## City of Ryde Submission

**DATA CENTRE - SSD-24299707  
17-23 Talavera Road, Macquarie Park**

**Alterations and additions to an existing data centre including relocation  
of drainage easement & pipes and tree removal**

**Submission Date: 21 January 2022**

DRAWING TITLE
SITE PLAN

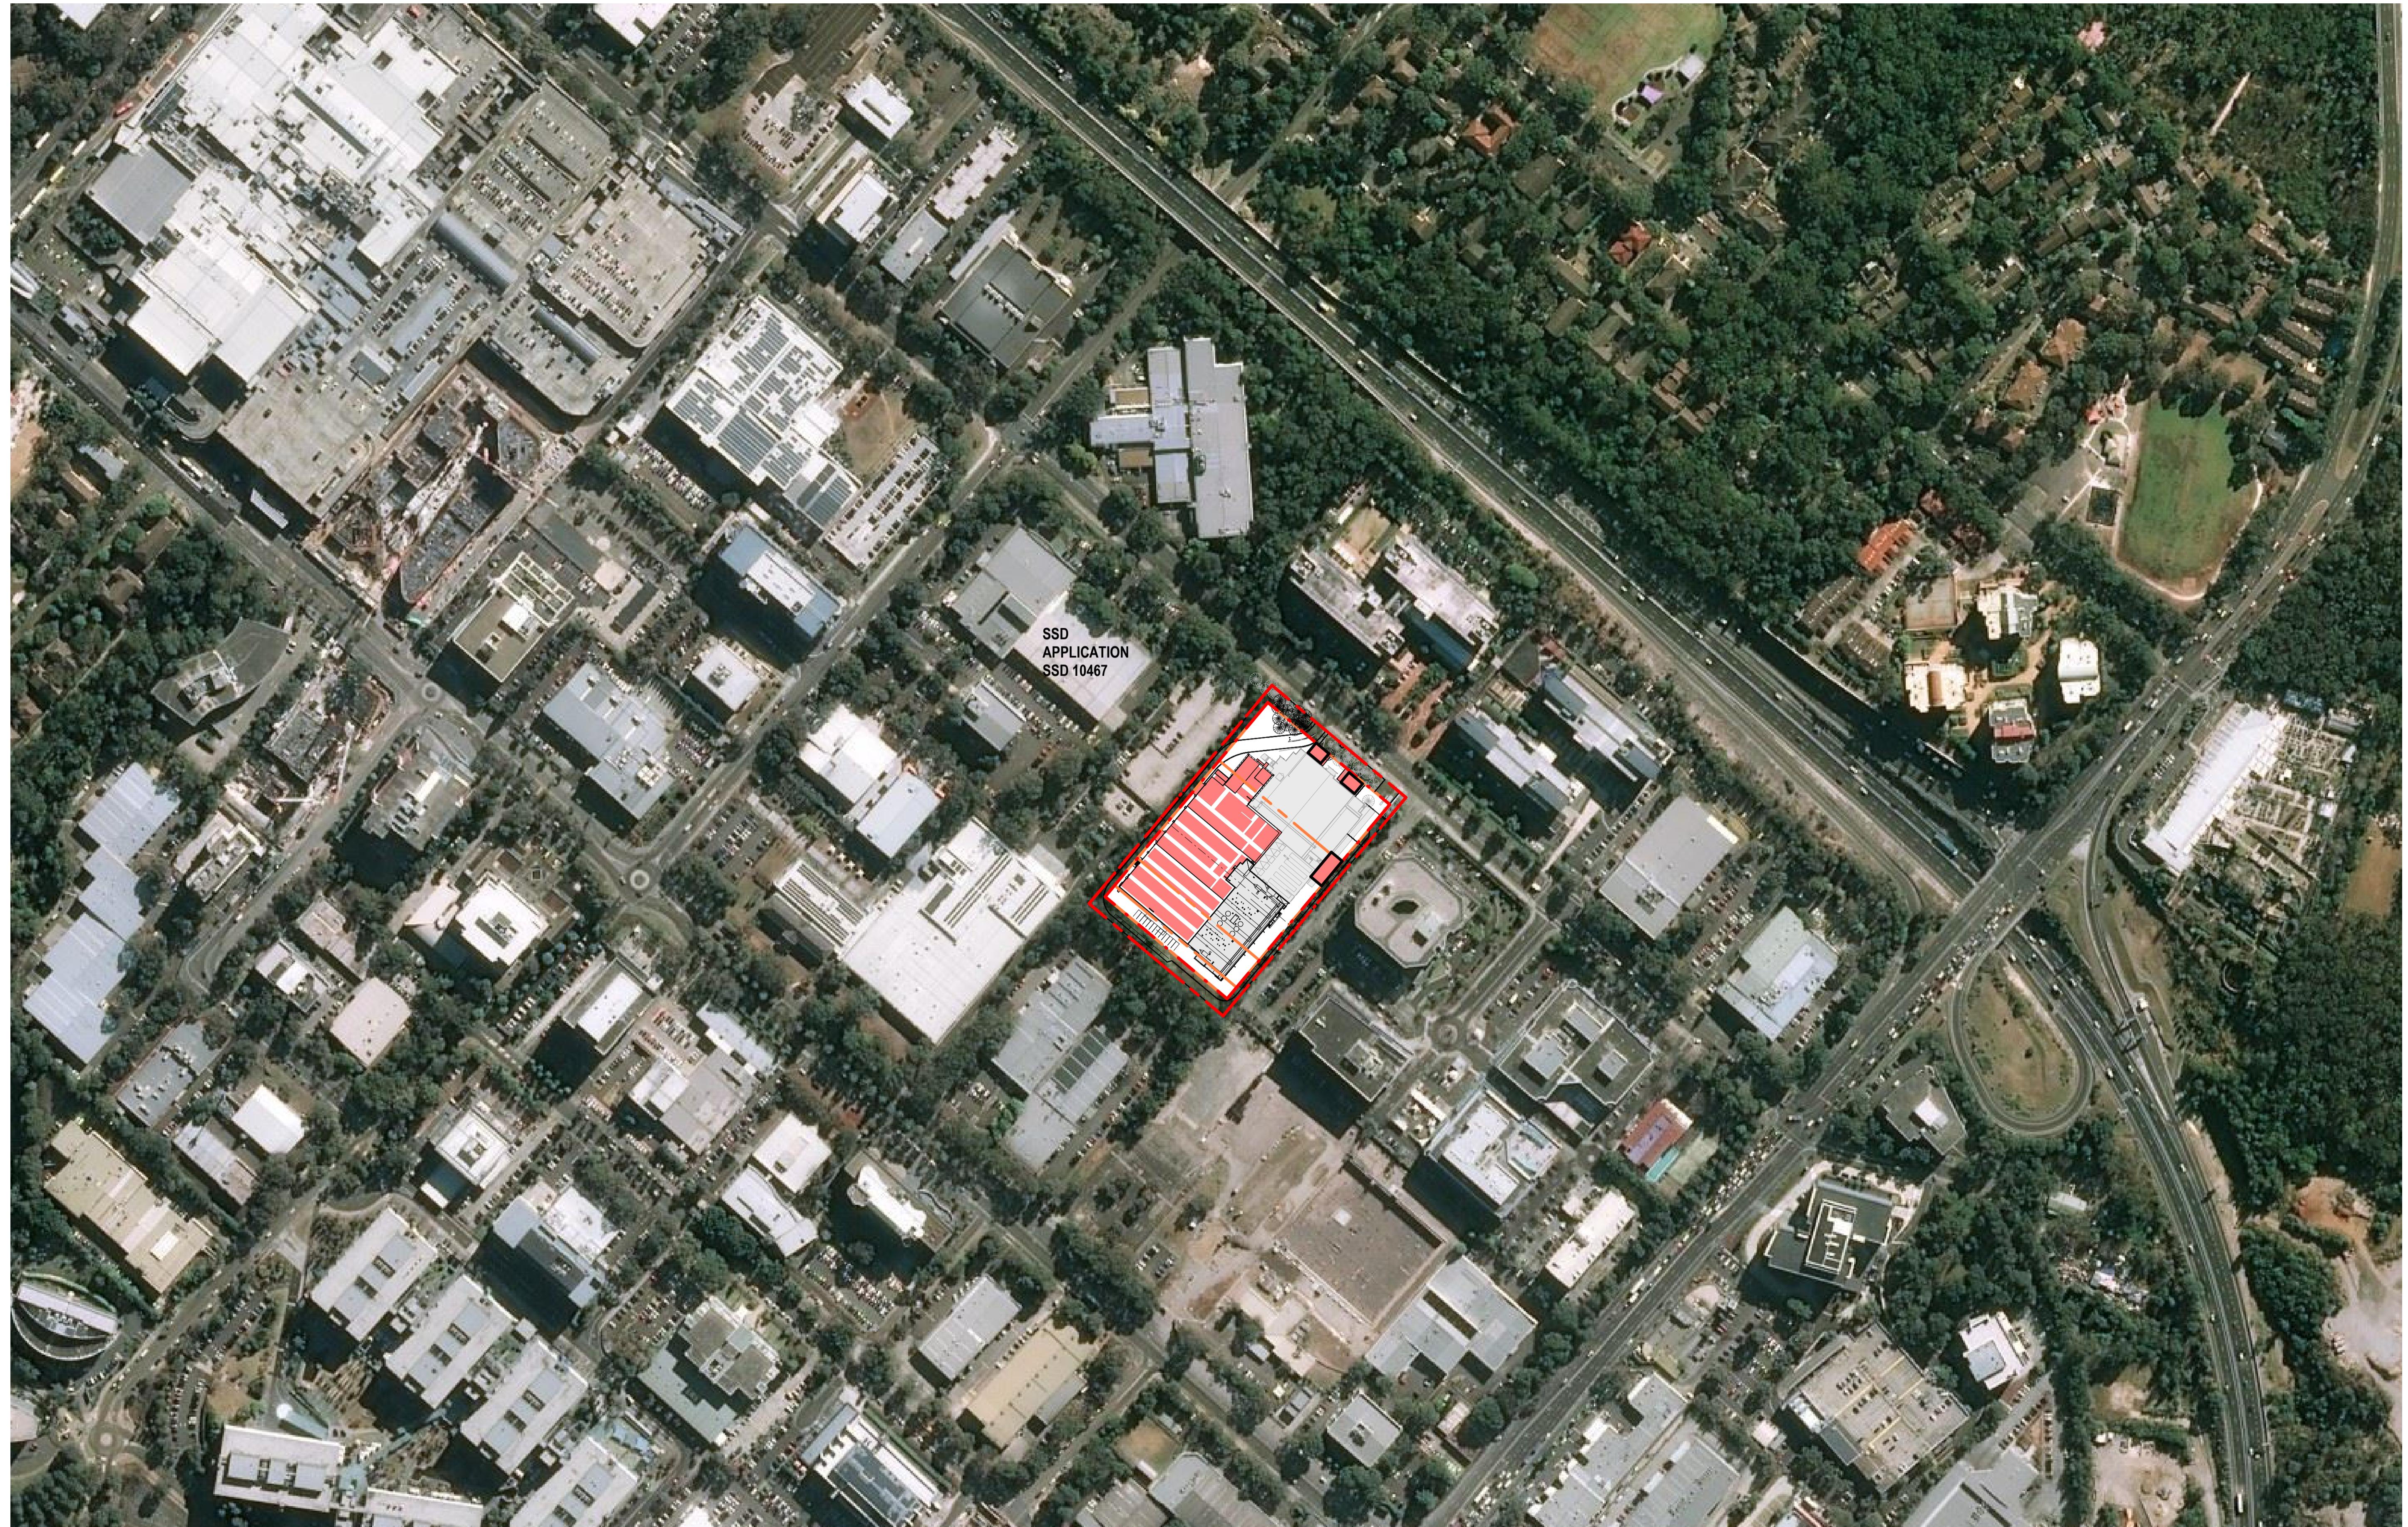
The SSD also seeks to relocate the easement further to the north western side with much longer run which is likely to incur greater costs on Council due to the longer run of the easement and there are also environmental concerns as detailed in this submission. Council will need the proponent of the new proposal to bear the costs associated with relocation of the easement and the stormwater pipe once or if any agreement is reached on a suitable location and specifications of the proposed new easement. In particular, the drainage relocation works must then occur with the SSD prior to the issue of any Construction Certificate.

The proposal is to further extend the building over existing pipeline located in existing easement, build over the new easement (which is currently outside the existing building footprint) and provide an alternate easement (proposed new easement) along its north western boundary for future relocation of the trunk drainage.

Despite the applicants insistence that the development will maintain clearance from the services, the plans seems to depict new columns in the existing easement or close to it (that contains the pipes) such that it presents considerable implications in terms of construction logistics and additional costs burden on Council. The proposal depicts various concerns with respect to existing easement and drainage infrastructure:

- i. The new works entail increased number of columns over a longer distance adjoining the existing easement, with some appearing to be located over the line. This will increase risks for Council and will hinder access to the trunk drainage line for maintenance. The new development is bigger in size and covers greater area over the easement which means that getting access to the easement is futured hindered. Accordingly, the revised application presents substantially less opportunity to access the drainage line, even for minor repair works which may be required.

- v. The side setback of 5m required under RDCP2014 has not been provided, that also requires landscaped setting and trees to be retained. The proposed easement results in removal of most of the trees.

- Plans are not dimensioned adequately.
    - The easement will require wider area along the building than shown on the architectural plan.
    - Provide setback dimensions and exact location of the easement from the boundary.

SITEWORKS AND STORMWATER
MANAGEMENT PLAN**

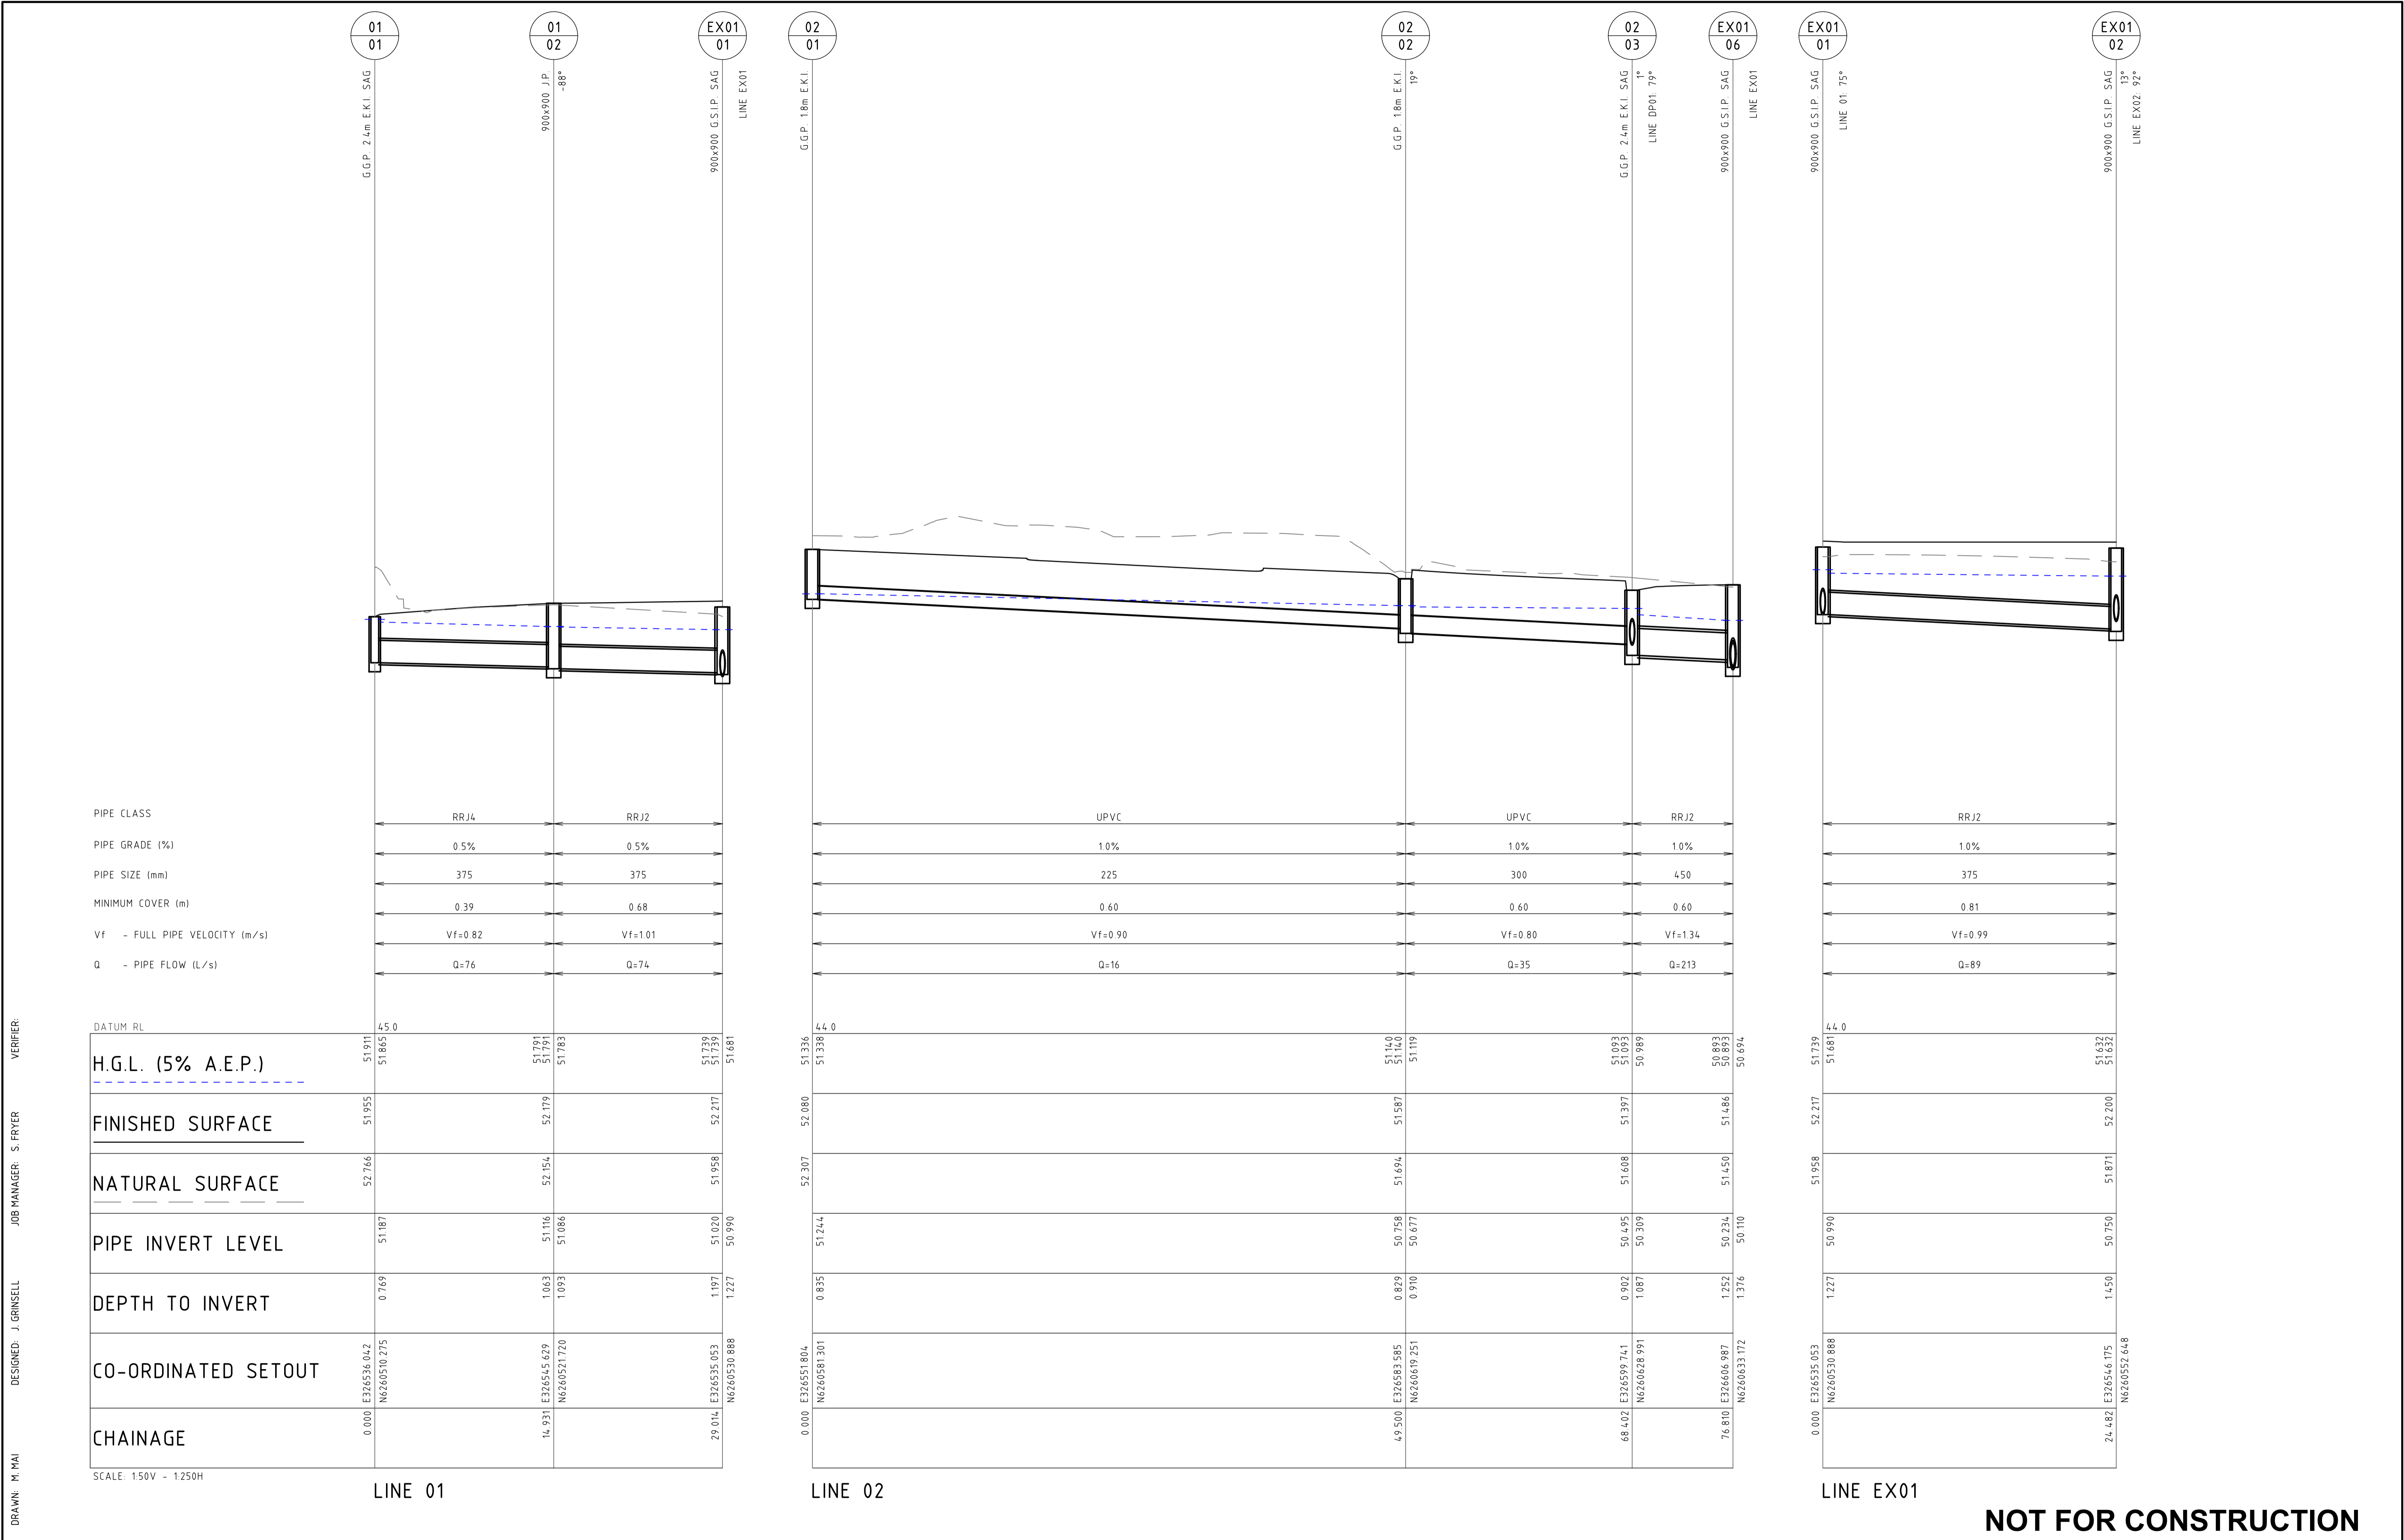
Further, the pipe relocation is not an improvement to Council's stormwater network, as it adds more pits, changes in direction and increases its length. The compromised flow and loss are expected to be compensated by the increase in diameter of the pipe.

- iv. The length of new easement would require much longer pipes and associated infrastructure compared to existing easement located under the building.

- vii. The Option lacks engineering details including the following:
  1. **Lack of clarity:** There is no clarity regarding how far away from the side boundary the edge of proposed easement will be located.

- All pipe class to be Class 4.
  - All new pits to be designed to reduce hydraulic losses.
  - Including longitudinal sections with hydraulic grade lines.
